**From:** Cornelis Duba <Cornelis.Duba@endeavourenergy.com.au>  
**Sent:** Friday, 22 September 2017 11:00 AM  
**To:** Chloe Dunlop  
**Cc:** Joanna Bakopanos; Philip Wilson  
**Subject:** URGENT ACTION REQUIRED: SSD7664 - Horsley Drive Business Park Stage 2  
**Attachments:** Endeavour Energy General Restrictions for Overhead Power Lines.pdf; Endeavour Energy MDI0044 Easements and Property Tenure.pdf; work\_near\_overhead\_power\_lines\_code\_of\_practice\_1394%5B1%5D.PDF; Safety+on+the+job.pdf; FactSheet\_Building\_Construction+web.pdf; emf-what-we-know-jan-2014-final\_1\_1.pdf

As discussed, the Department is finalising the assessment of the Horsley Drive Business Park Stage 2 State Significant Development (SSD7664) and seeks comments from Endeavour Energy relating to works within the high voltage powerline easement. The Concept Proposal is for the establishment of a general and light industrial and warehouse and distribution centre estate and the Stage 1 DA involves subdivision of the site, bulk earthworks and stormwater works.

As part of the Stage 1 DA, stormwater works are proposed in the easement located on part of Lot 23 DP 13961 which is currently owned by TransGrid. How

DRAWING TITLE	
CONCEPT CIVIL WORKS PLAN SHEET 1	
DRAWING No	ISS
Co11492.11- DA41

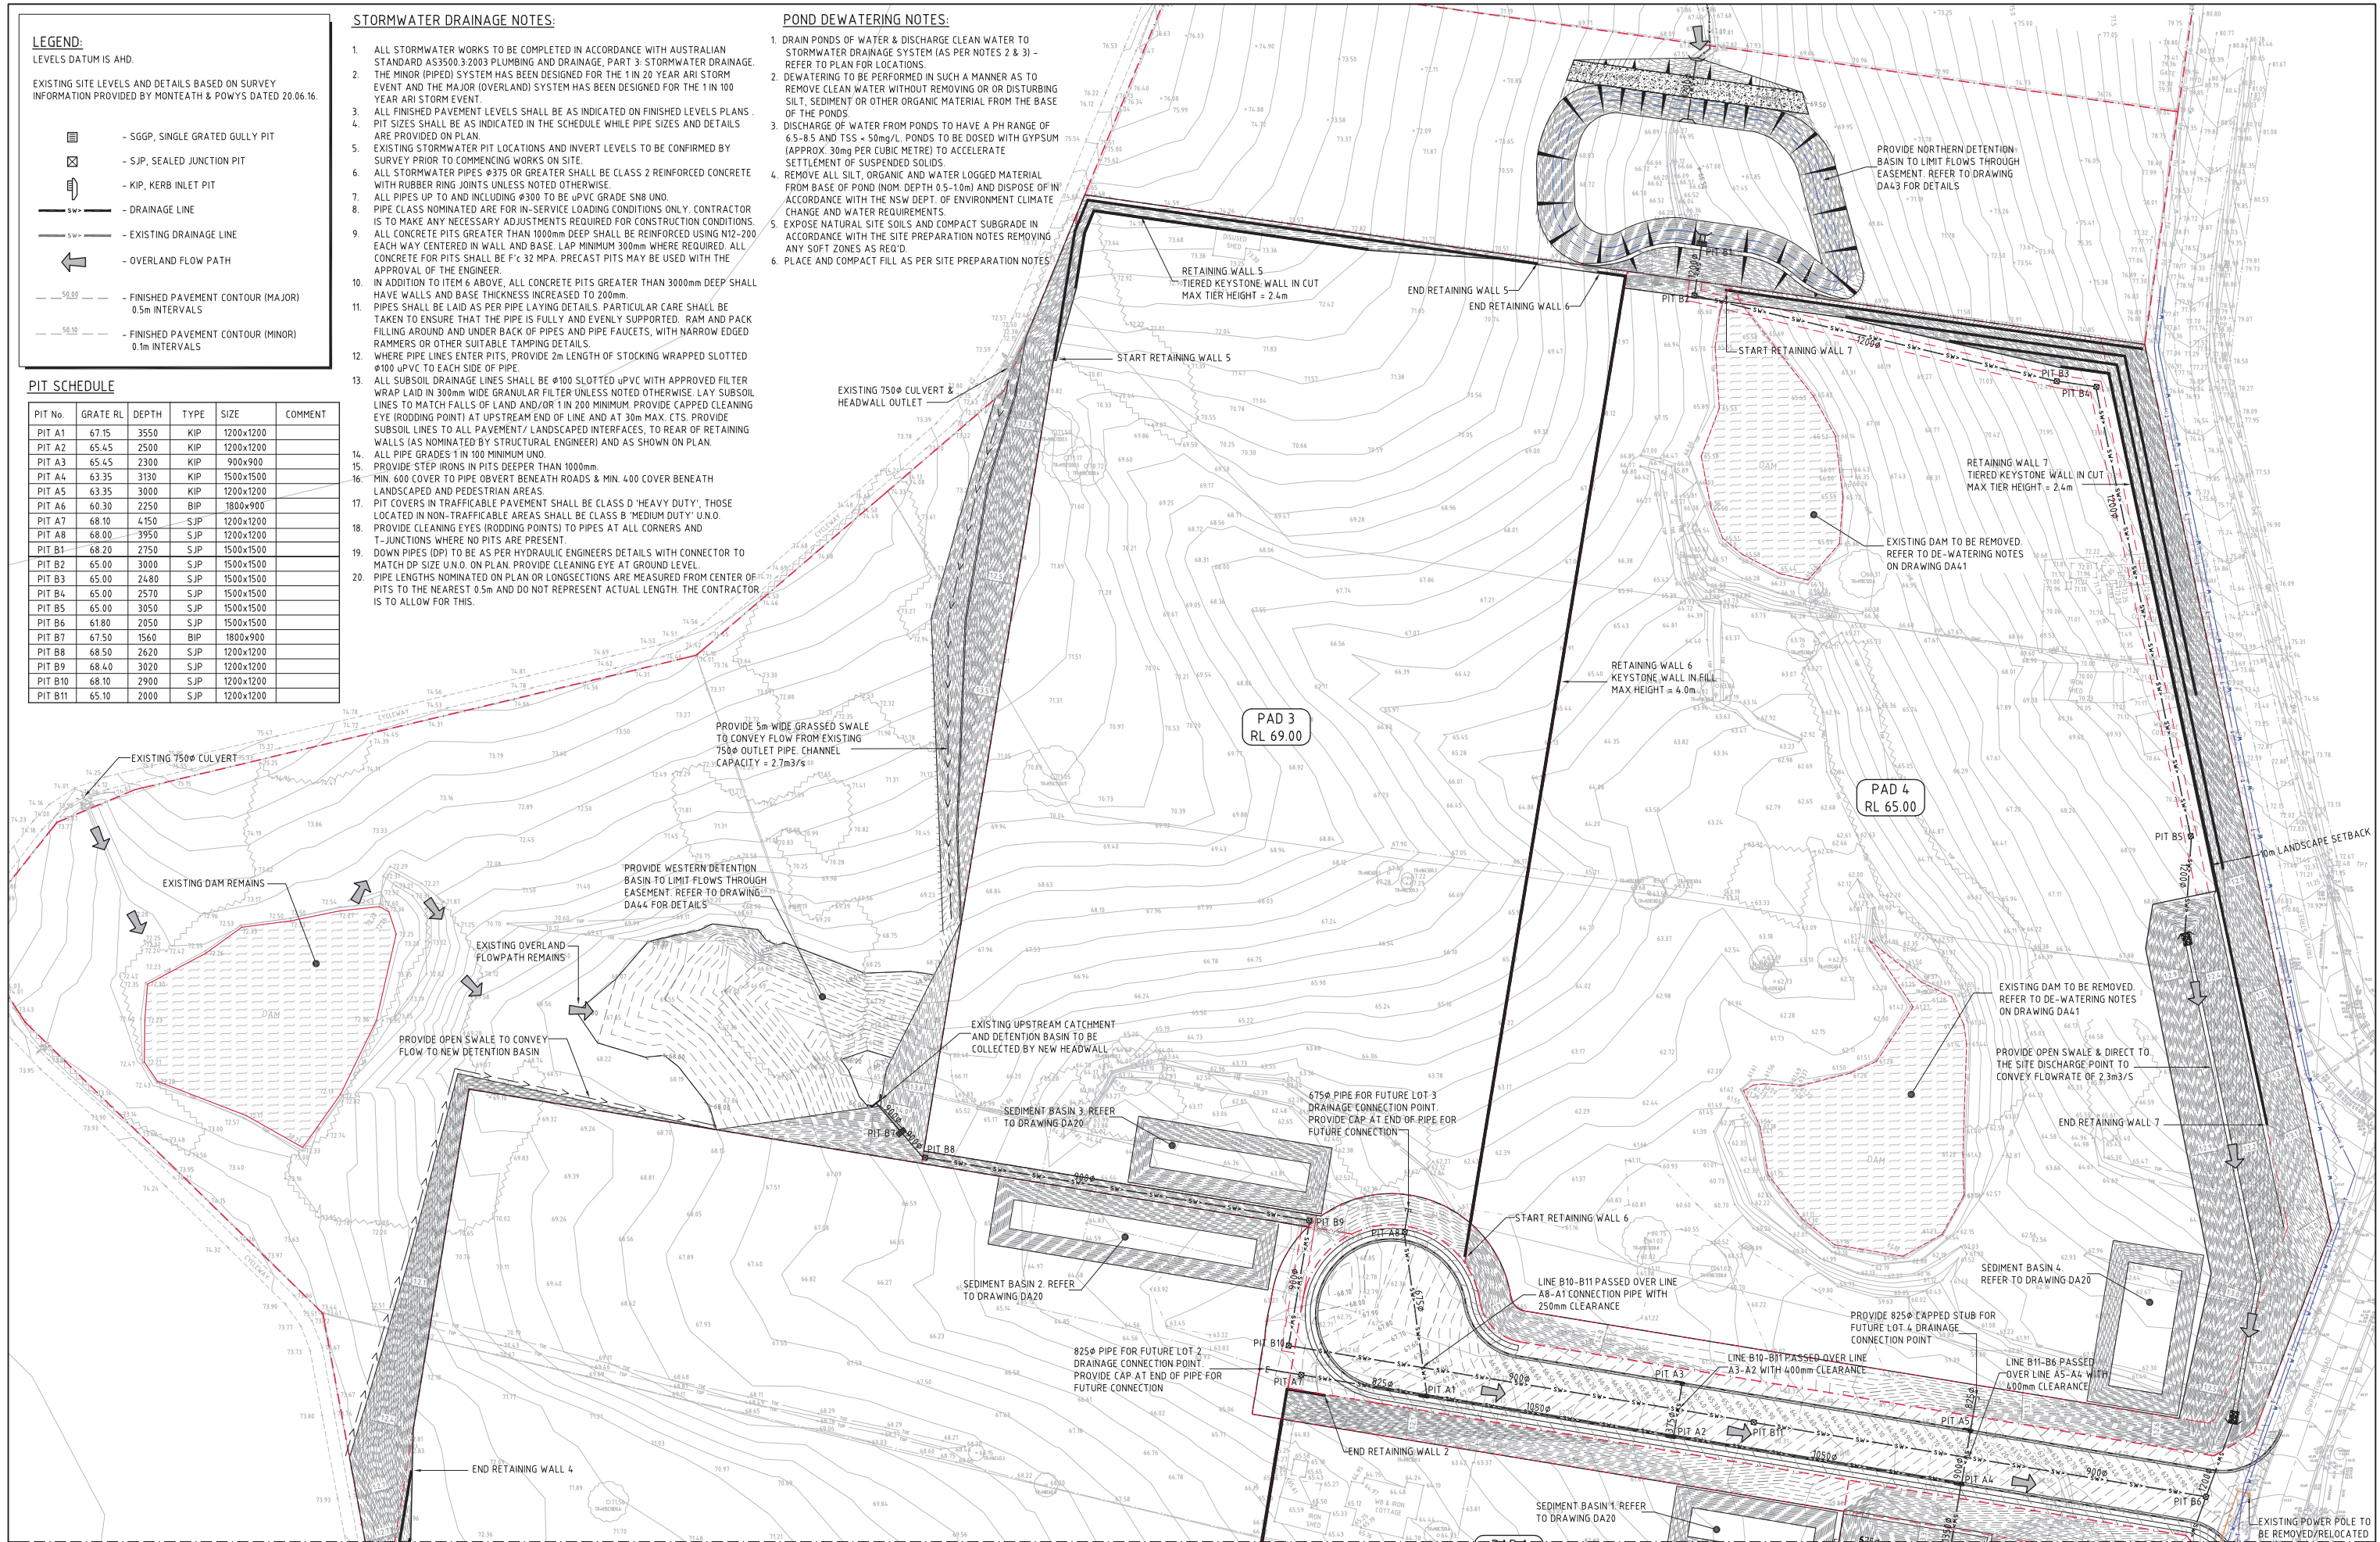
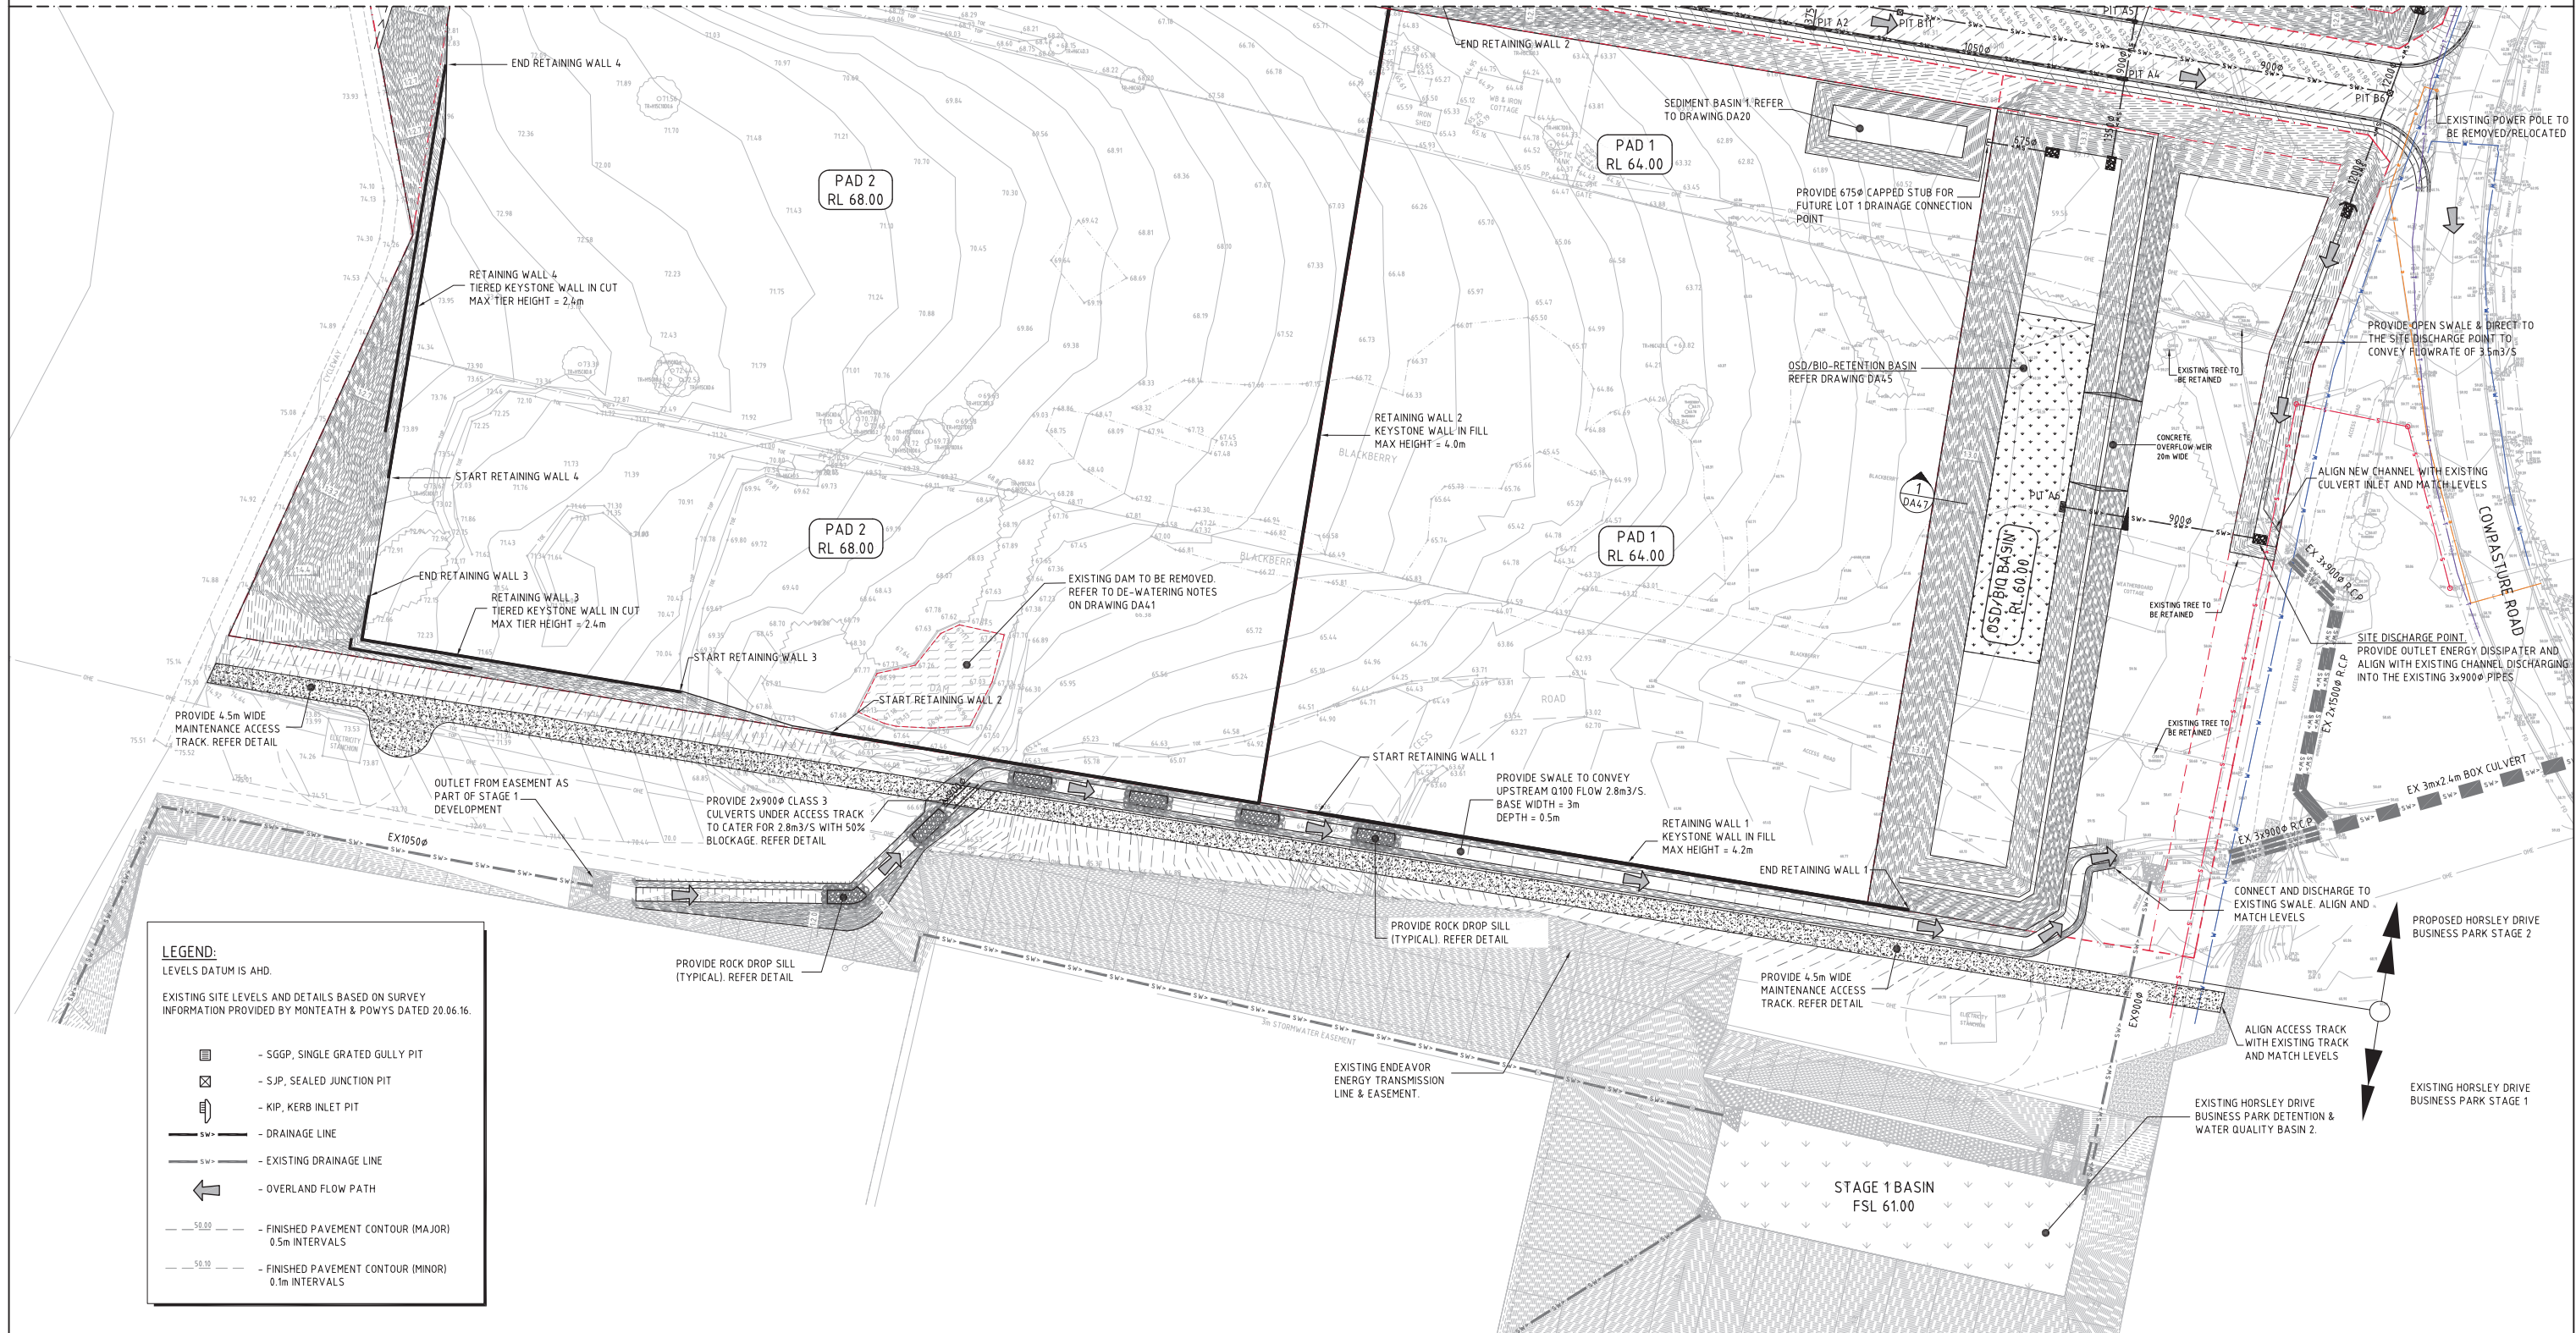
In regards to part of the Stage 1 DA stormwater works being proposed in the easement, the following section of MDI 0044 is applicable:

#### 5.14.4.14 Installation of utility services

Applications for the installation of telephone, water and sewerage services (overhead, underground, or on the surface) may be considered for approval by Endeavour Energy's Mains Assets Manager. The approval of the installation of these services will be based on:

- There is no practical alternative available;
- Any services within 15 metres of a structure must be constructed of non-conducting materials;
- The integrity of all line structures and stay pole/wires are to be maintained at all times;
- Designers and installers of utility services must consider any hazards associated with induced voltages and transferred earth potentials, in accordance with AS 4853, which must be controlled. Applications will require a risk assessment and proposed controls for each of the identified hazard.

Establishment of an easement for other utilities assets within Endeavour Energy's easement may be required.

As the proposed works will encroach/affect Endeavour Energy's easements, contact must first be made with the Endeavour Energy's Easements Officer, Philip Wilson, on 9853 7110 alternately [Philip.Wilson@endeavourenergy.com.au](mailto:Philip.Wilson@endeavourenergy.com.au). The applicant will need to address the relevant provisions of MDI 0044 and the Easements Officer will refer the matter to the Mains Asset Manager for determination.
